## Ribble Valley Borough Council

### DELEGATED ITEM FILE REPORT - REFUSAL

<b>Application No:</b>	3/2015/0272
<b>Development Proposed:</b>	Erection of detached double garage
<b>Site Address:</b>	Former agricultural shippon adjacent to Curtis House, Chipping Road, Longridge, PR3 2NB.

PROPOSED SITE PLAN

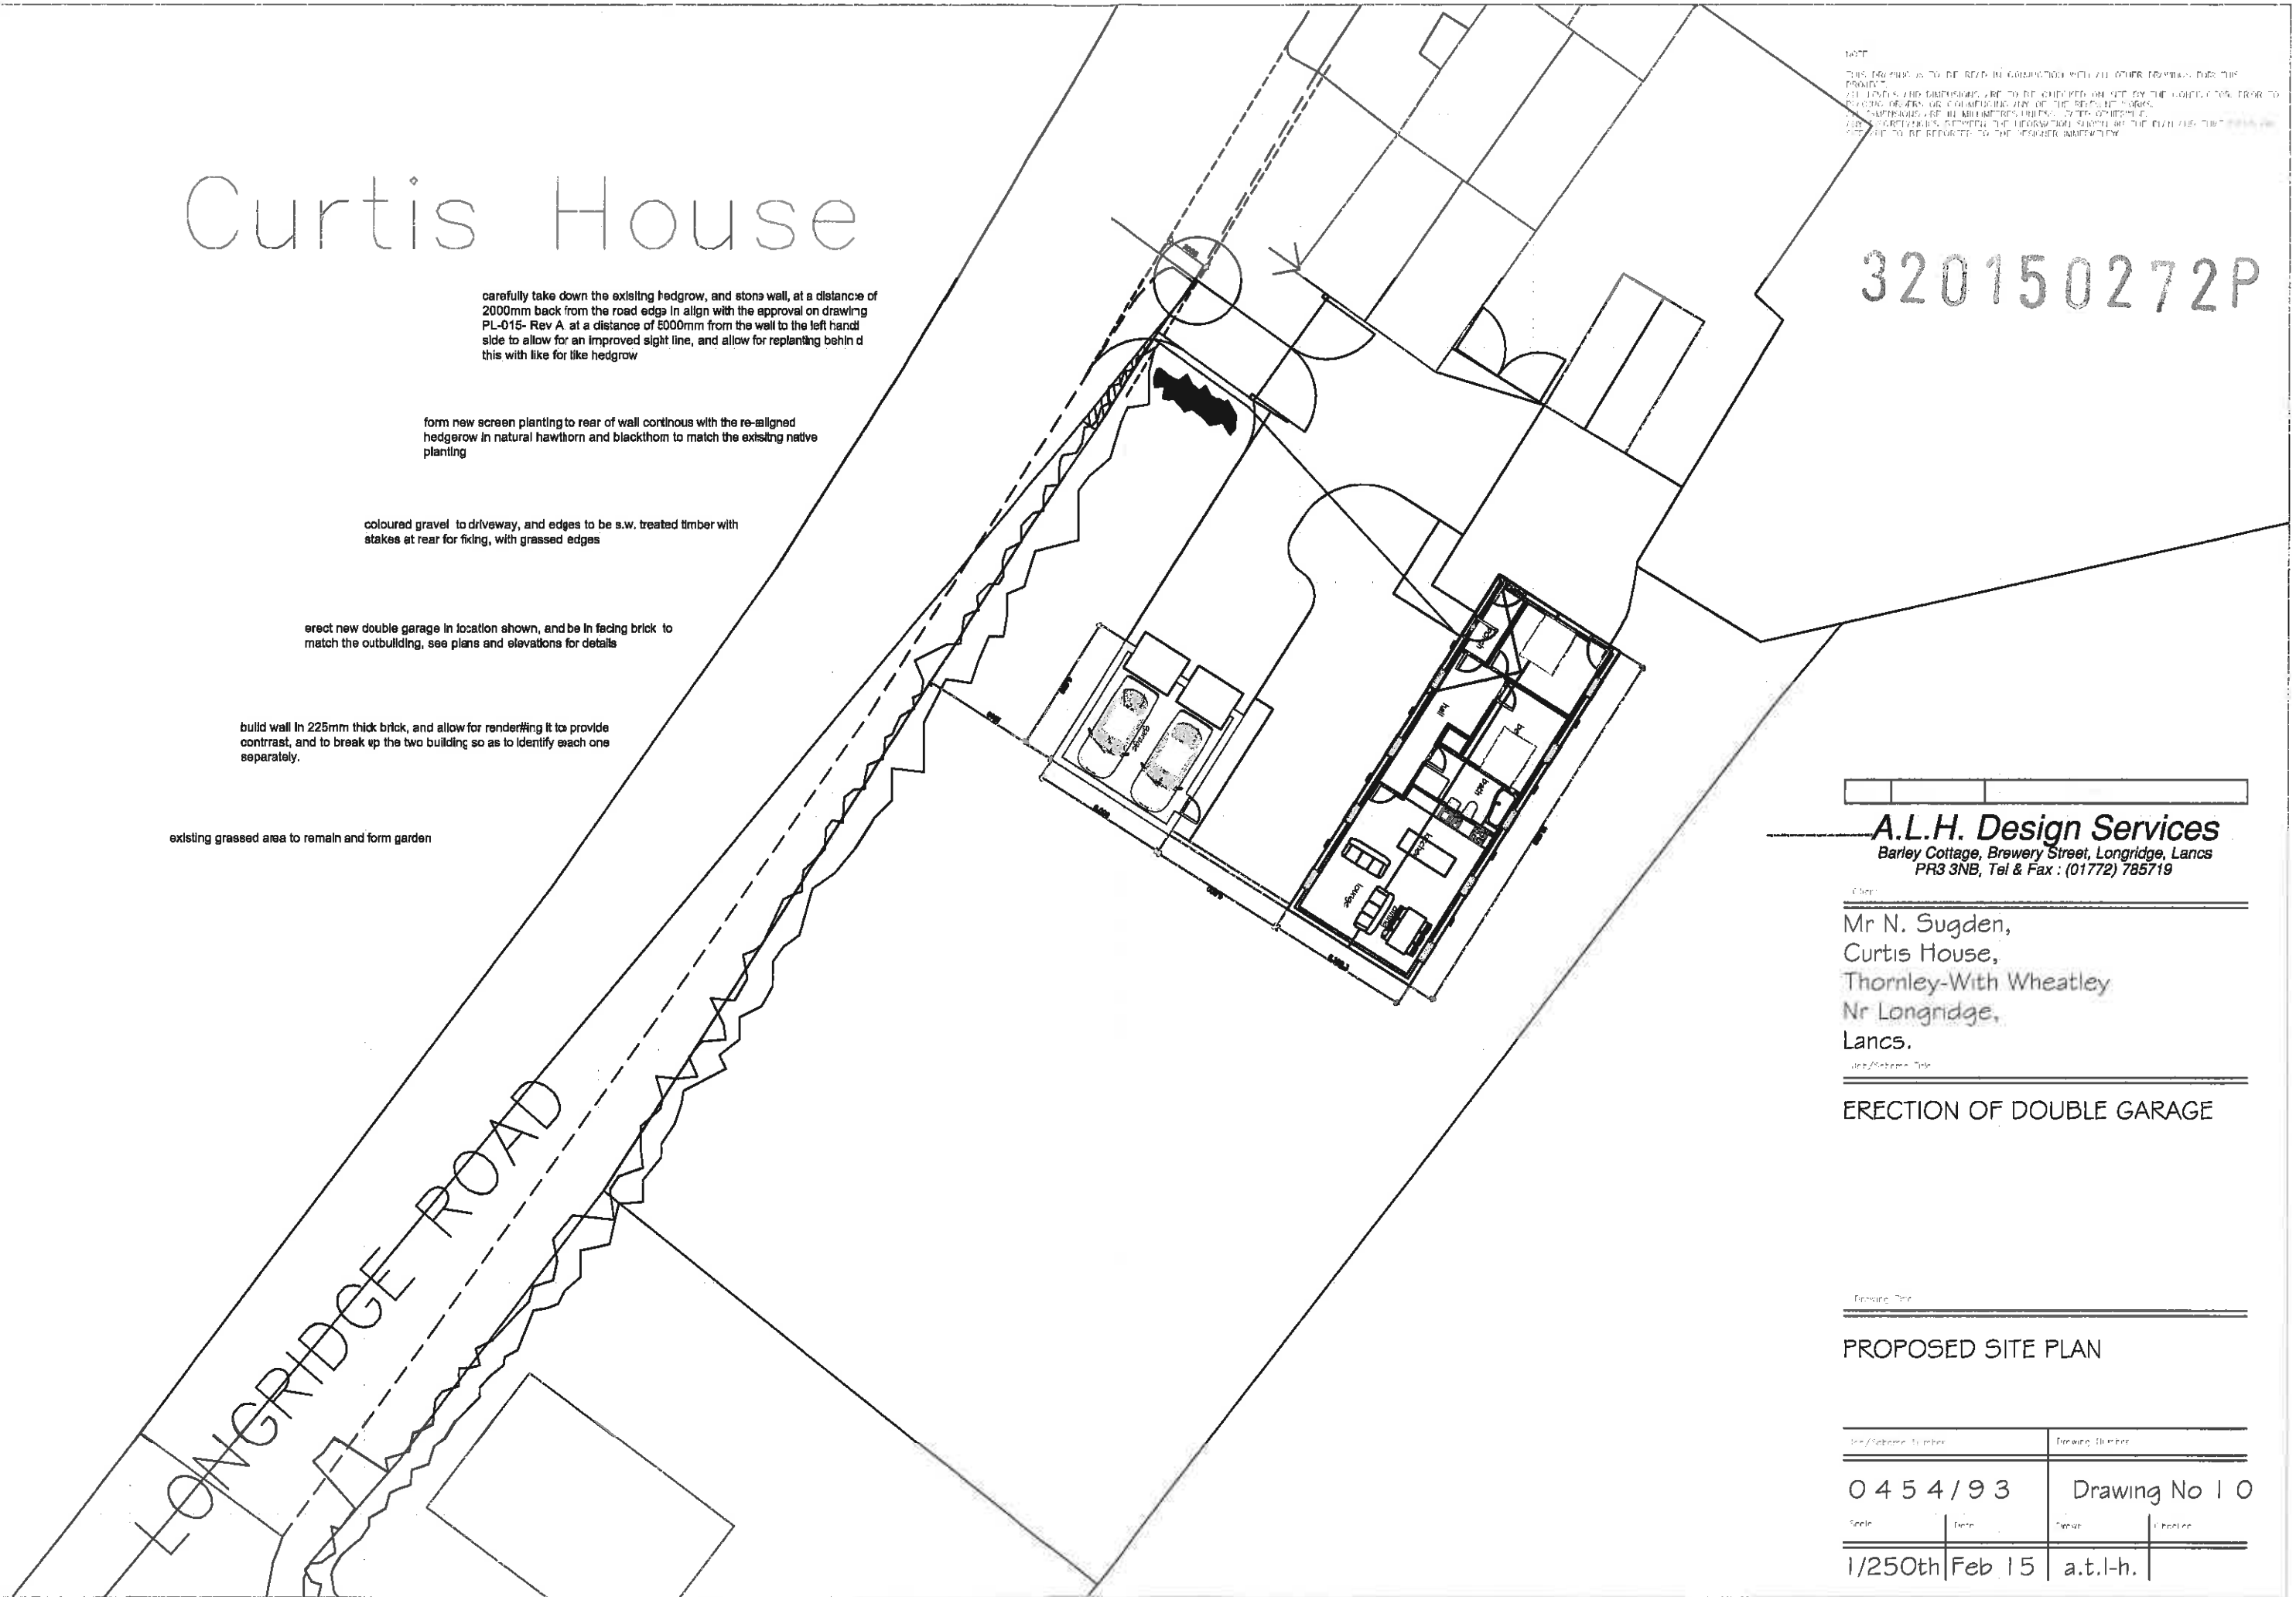
Environment Directorate (County Surveyor) - the site plan (Dwg.10) for the current application appears to differ from the previously agreed sight line (App 3/2014/ 0425 Dwg. No. PL015 Rev 1) in that the sightline is being measured to the centre of the carriageway whereas it should be measured to the nearside kerb of Longridge as per the previously approved plan.

With regards the first matter highway safety, the Highway Authority raises concerns over the inconsistencies between the Site Plan (Dwg.10) for the current application to that which the LPA, in conjunction with the Highway Authority, previously agreed - Application 3/2014/0425/P, Drawing No. PL015 Rev 1. On this application the sightline is being measured to the centre of the carriageway whereas it should be measured to the nearside kerb, as per the previously approved plan. The proposed sight line is therefore inadequate and would not result in a safe access leading to conditions that would be adverse to highway safety.

The above said, subject to the submission and approval of a revised site layout plan in accordance with the above requirements it is likely that the Highway Authority would raise no objection to the proposal on highway grounds.

PROPOSED GARAGE ELEVATIONS

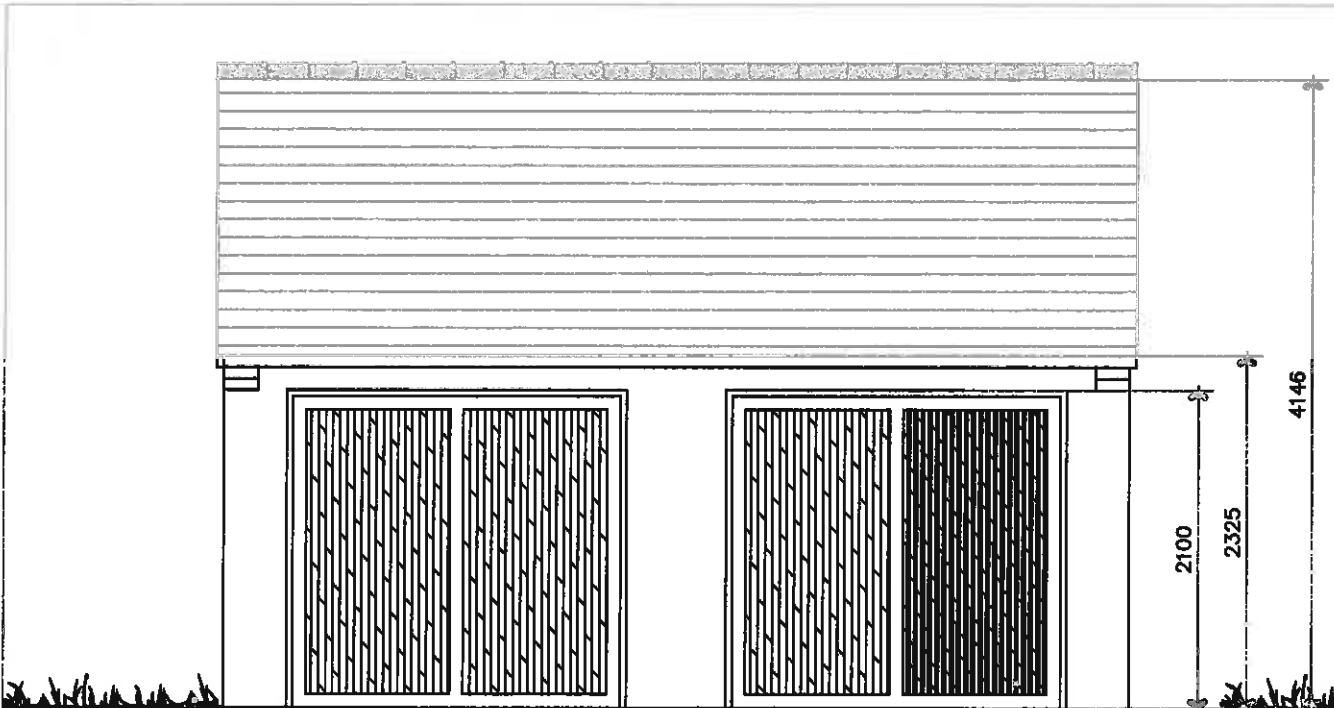
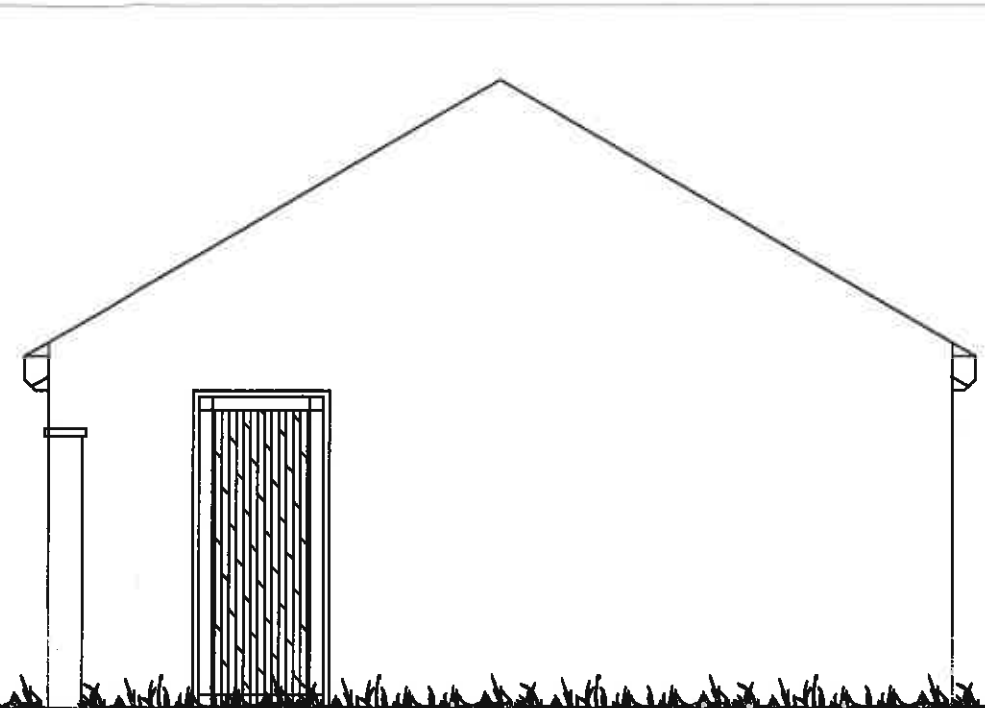
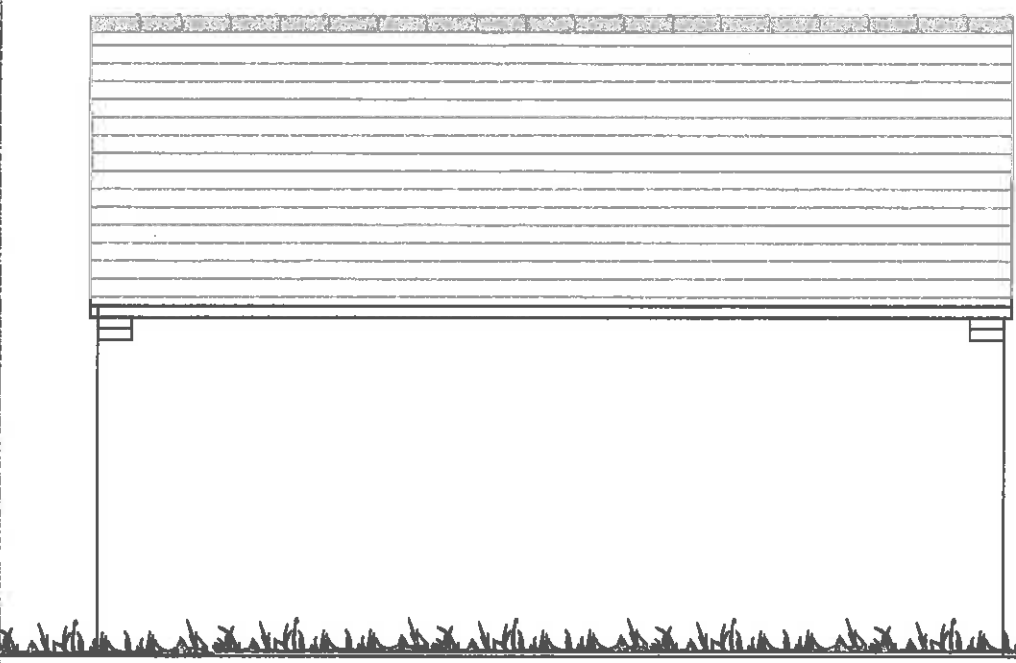
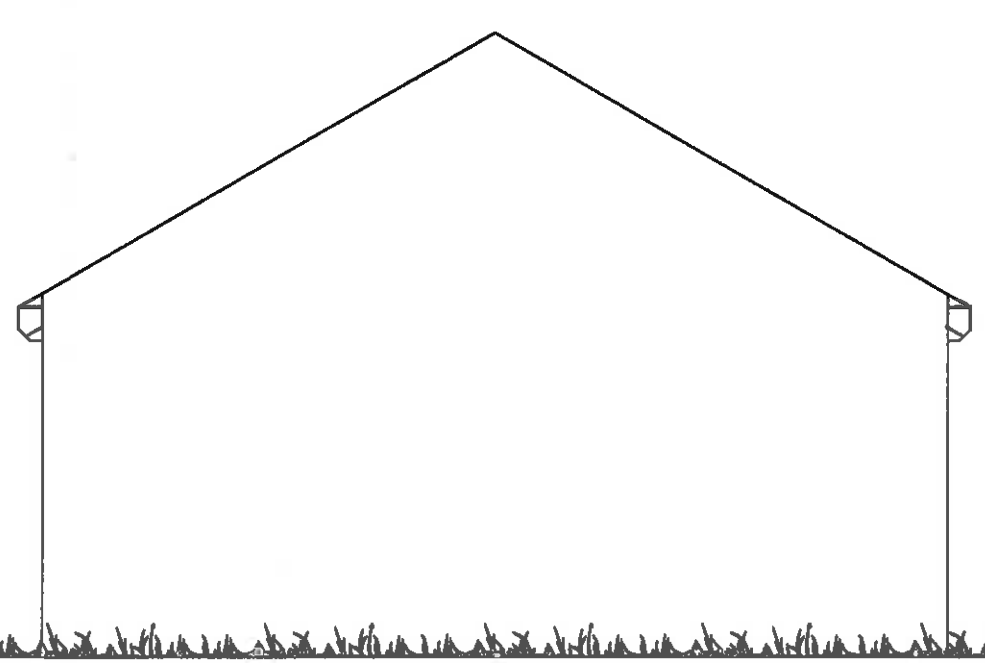
Also there is a discrepancy between the elevation plan and the site layout plan for the current application with the former showing a 3rd parking space adjacent to the proposed garage. Again whilst not a significant concern I would need to see a plan showing the proposed parking arrangements for the site to be certain that the parking does not affect the ability of vehicles to enter and leave in a forward gear. Subject to the submission and approval of a revised site layout plan in accordance with the above requirements I would raise no objection to the proposal on highway grounds.

In addition, the Highway Engineer is concerned that there is a discrepancy between the submitted Elevations plan and the Site Layout plan, with the former showing a third parking space adjacent to the proposed garage. Whilst the Highway Authority says it is not a significant concern they require a plan showing the proposed parking and manoeuvrability arrangements for the site in order to be certain that the parking does not affect the ability of vehicles to enter and leave in a forward gear. At this point in time, the proposal is thus not acceptable in highway safety terms.

PROPOSED GARAGE ELEVATIONS
 (Streetscene)

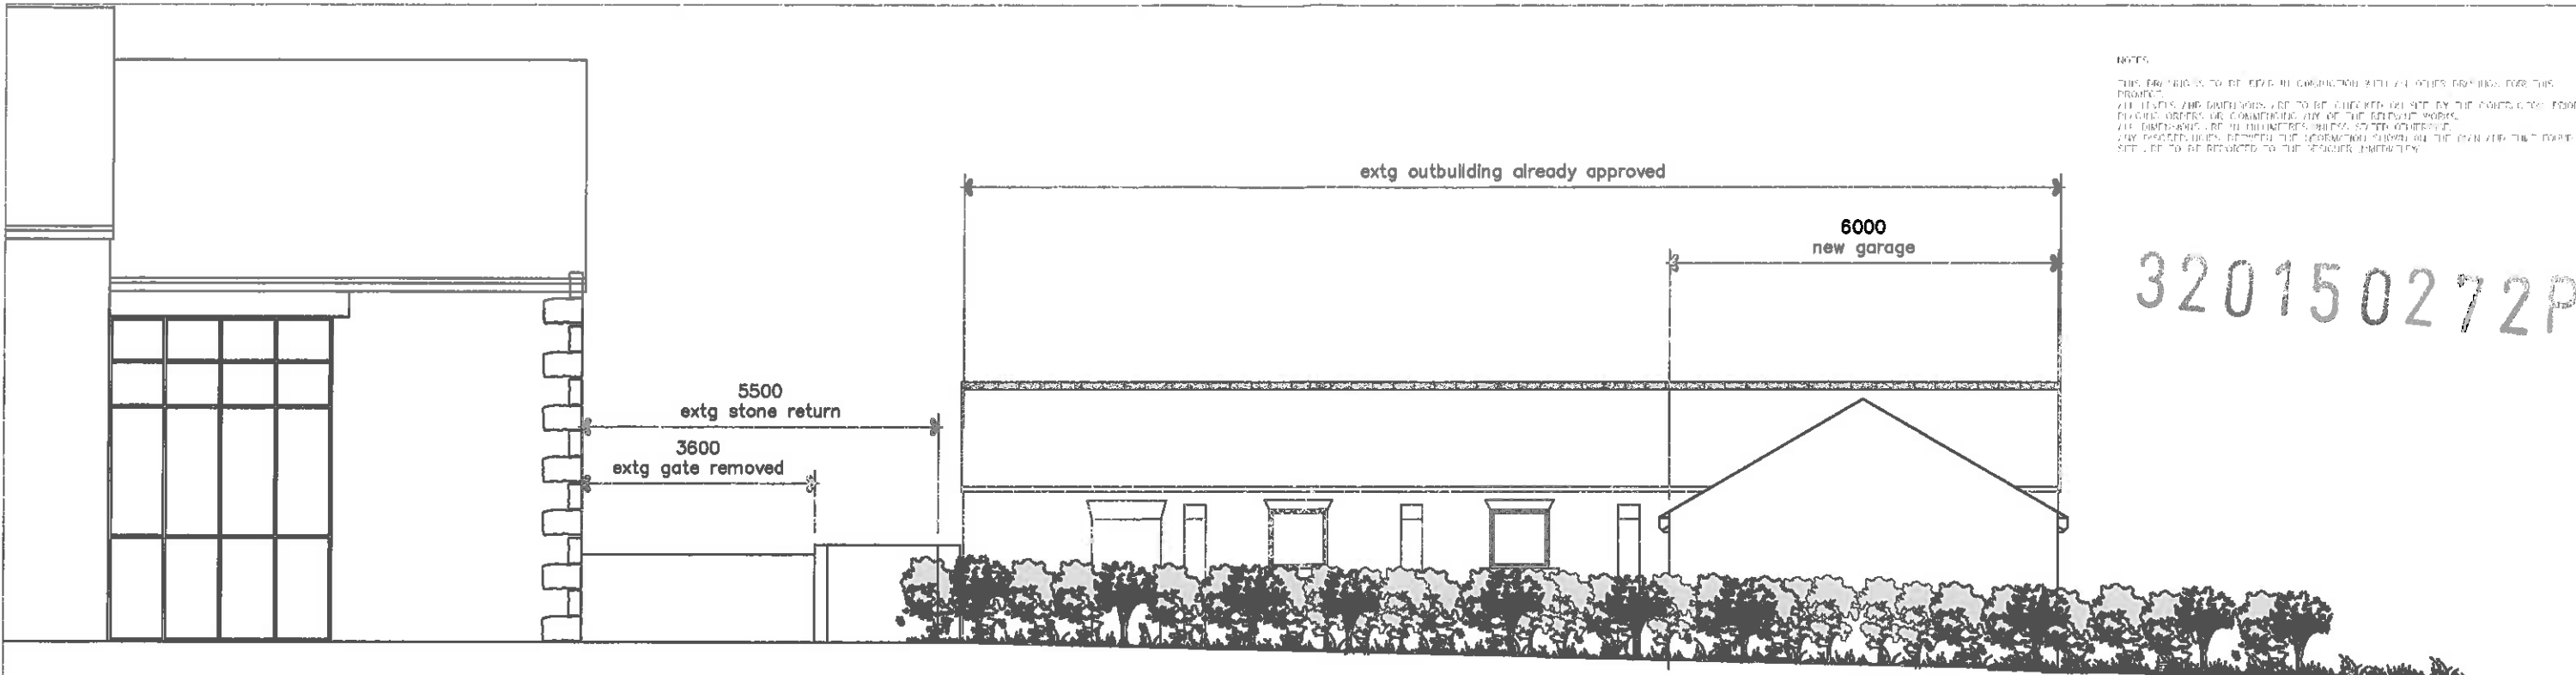
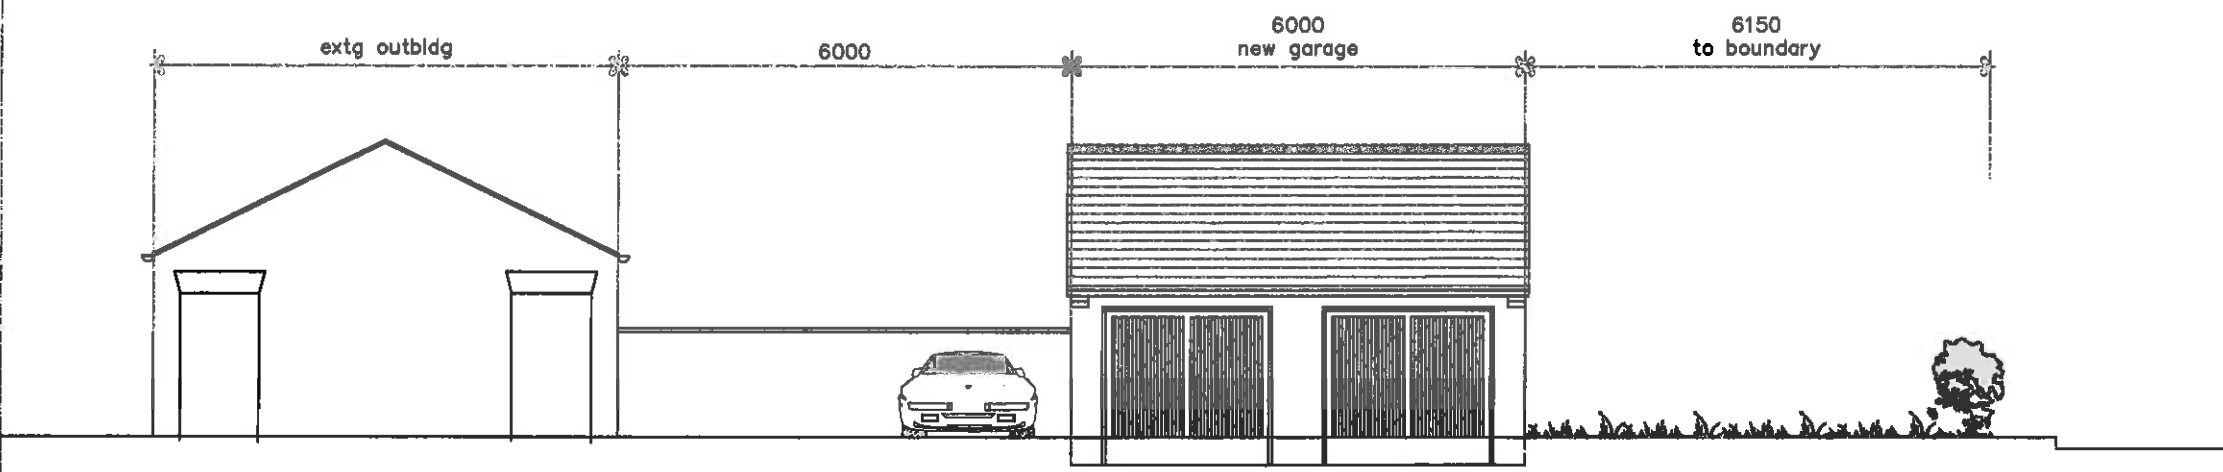
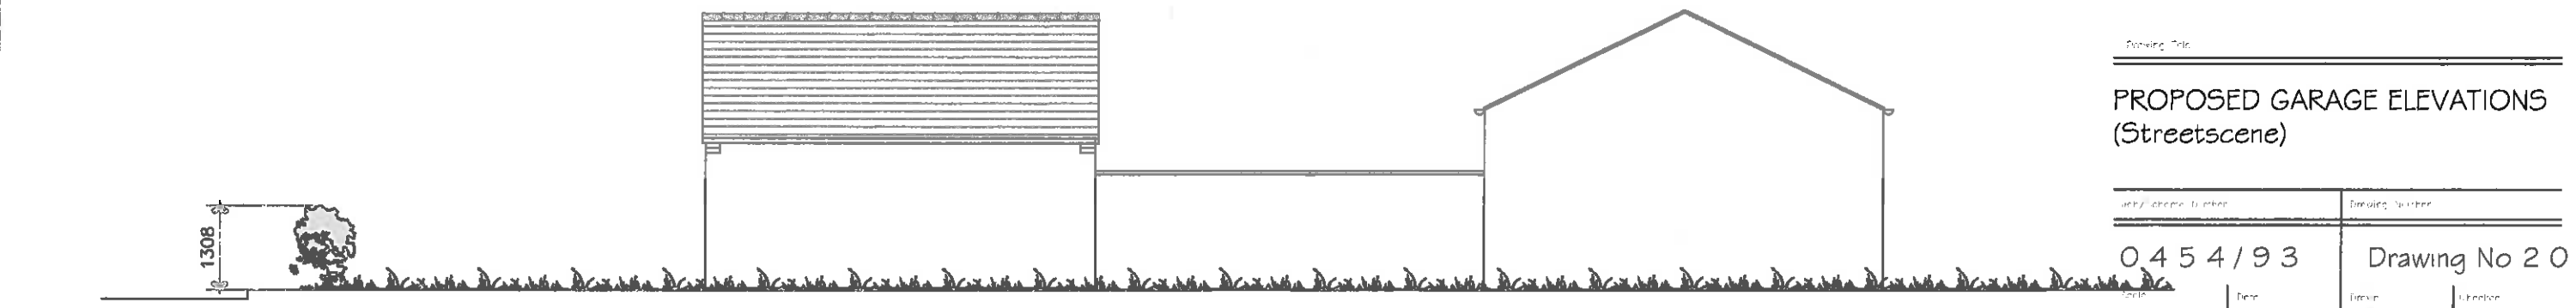
When travelling along Chipping Road, the proposed building would conflict with the linear form of the house to which the building formally related (Curtis House), the properties in the locality which all run parallel with the main road, and the traditional building to which the application relates. In addition; the proposals would appear suburban in their size and design. This combined with the height of the garage matching that of the rural building to which the garage would relate (see Elevation form Curtis House and Elevation from Lords Lane) and its orientation conflicting with the linear pattern of development in the locality, the result would be a prominent and dominant addition within the street scene which would seriously detract from the visual amenities of the locality.

The addition of the proposed rendered wall connecting the garage to the building in question, would appear totally suburban in its appearance and would conflict with the traditional rural character, appearance and setting of the red brick barn to which the proposal would relate and Curtis House to which the building was formally related, further justifying the reasons for recommending this application be resisted.

To clarify, the proposals would dominate the traditional building to which they would relate and consequently the garage would appear prominent and discordant in the rural street scene. It is considered that the proposals would seriously undermine the rural character and appearance and setting of the traditional rural building, and the visual amenities of the locality that is so important in both its own right and in contributing to the setting of the AONB landscape. On this basis, the proposals would significantly harm the rural landscape and scenic beauty of the area and the visual amenities of the locality and consequently it is thus recommended that the application be strongly resisted.
